# COUNTY COUNCIL'S RESPONSE TO CONSULTATION ON THE FOLLOWING DEVELOPMENT PROPOSAL

**Application No:** 20/02453/F

**Proposal:** A fuel depot including ancillary offices, the installation of plant and hardstanding

**Location:** Hornton Grounds Quarry, Hornton

Title: PROPOSED SITE LAYOUT

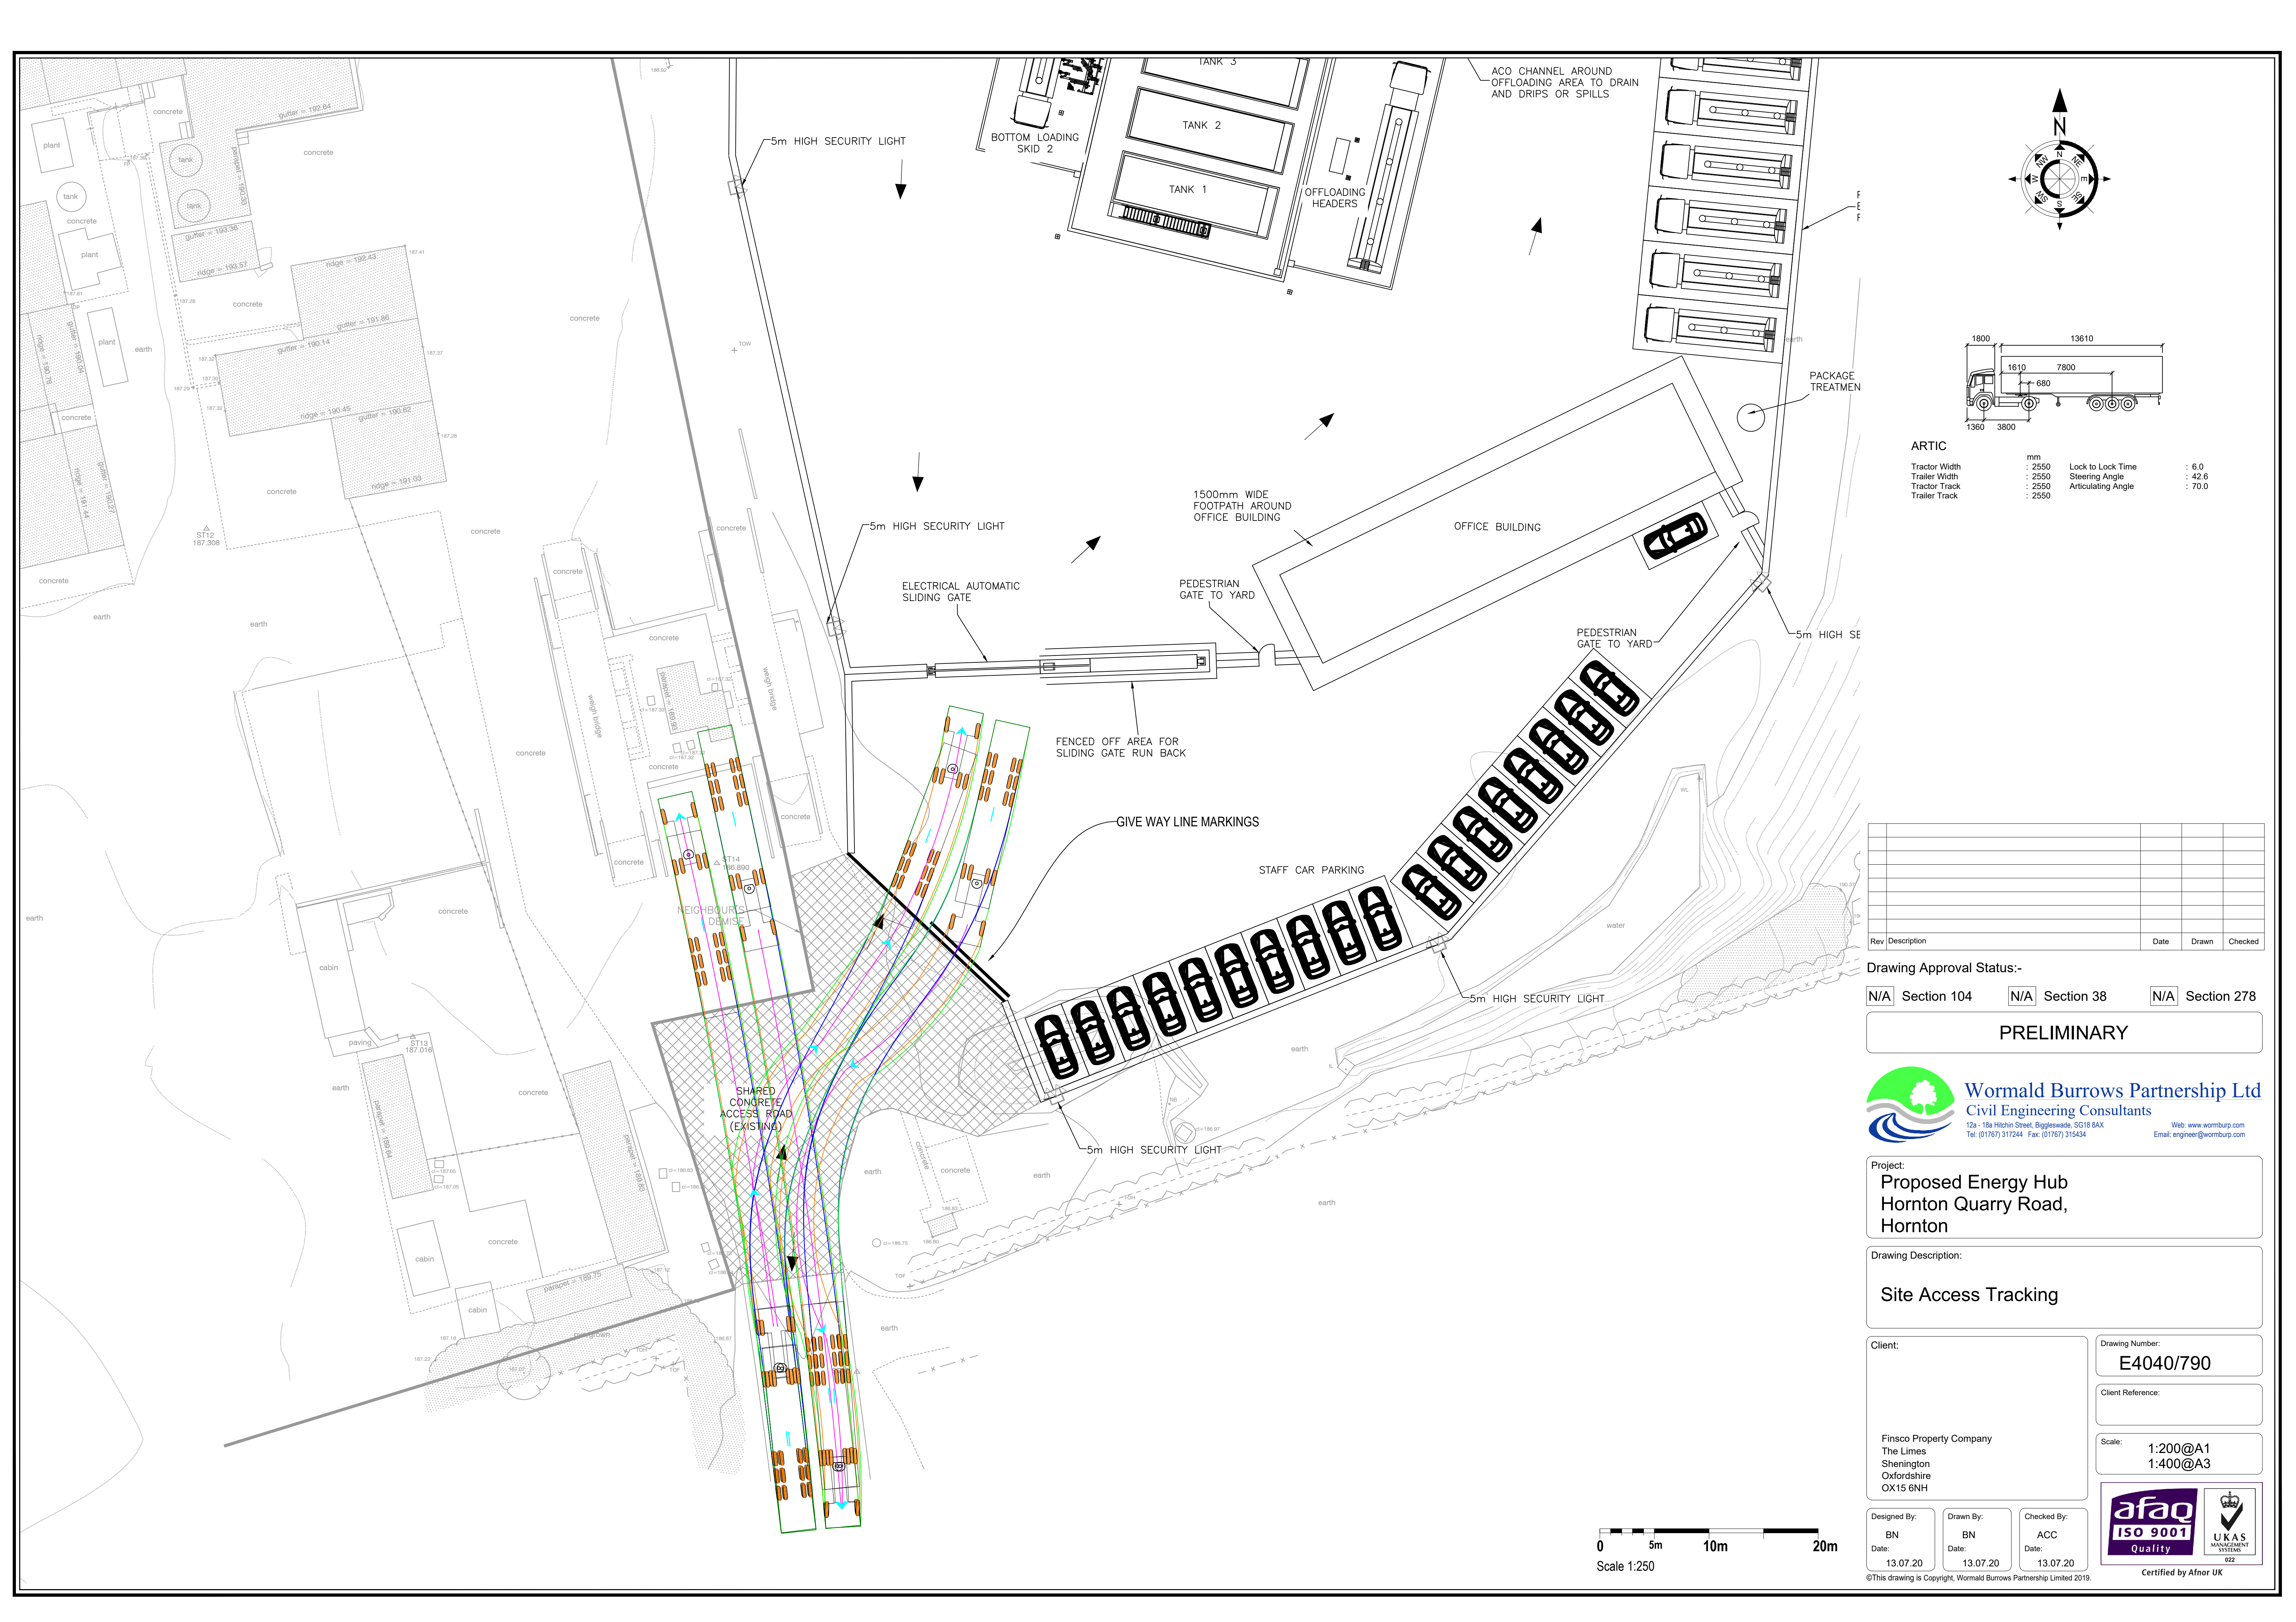
Although there is an existing wide bellmouth junction to the A422 and ghosted right turn lane, it has not been demonstrated in the application that the junction is suitable for the significant intensification of use.

The A422 is subject to the National Speed Limit (60mph) so the requirements of the Design Manual for Roads and Bridges apply. As a speed survey has not been undertaken, the visibility splay Y distance needs to be at least 203m. The presence of the ghosted right turn lane means that it is not a “simple” priority junction so the X distance will be 4.5m.

Having looked at Google Earth, Streetview and the Highway Record, I am doubtful that these visibility splays may be achieved, particularly looking in a north-westward direction. The splay would have to be entirely within the highway boundary or over land controlled by the applicant; however, the blue line area is not shown on the Location Plan (and the red line area does not extend to the public highway). The visibility splay must not be across third-party land. For the junction to be considered acceptable for the increased use, predominantly by slow-moving HGVs, the visibility splays need to be plotted on a topographical survey, with the full extent of land ownership and highway boundary being marked on. Therefore, unless it can be demonstrated otherwise, I consider that the development will have an unacceptable impact on highway safety, which is contrary to the NPPF and reason for objection.

Prior to the commencement of the development hereby approved, full details of the access vision splays, including layout and construction shall be submitted to and approved in writing by the Local Planning Authority. Thereafter, and prior to the first occupation of the development approved the vision splays shall be constructed in accordance with the approved details and the land and vegetation within the vision splays shall not be raised or allowed to grow above a maximum height of 0.6M above carriageway level. Reason - In the interests of highway safety and to comply with Government guidance contained within the National Planning Policy.
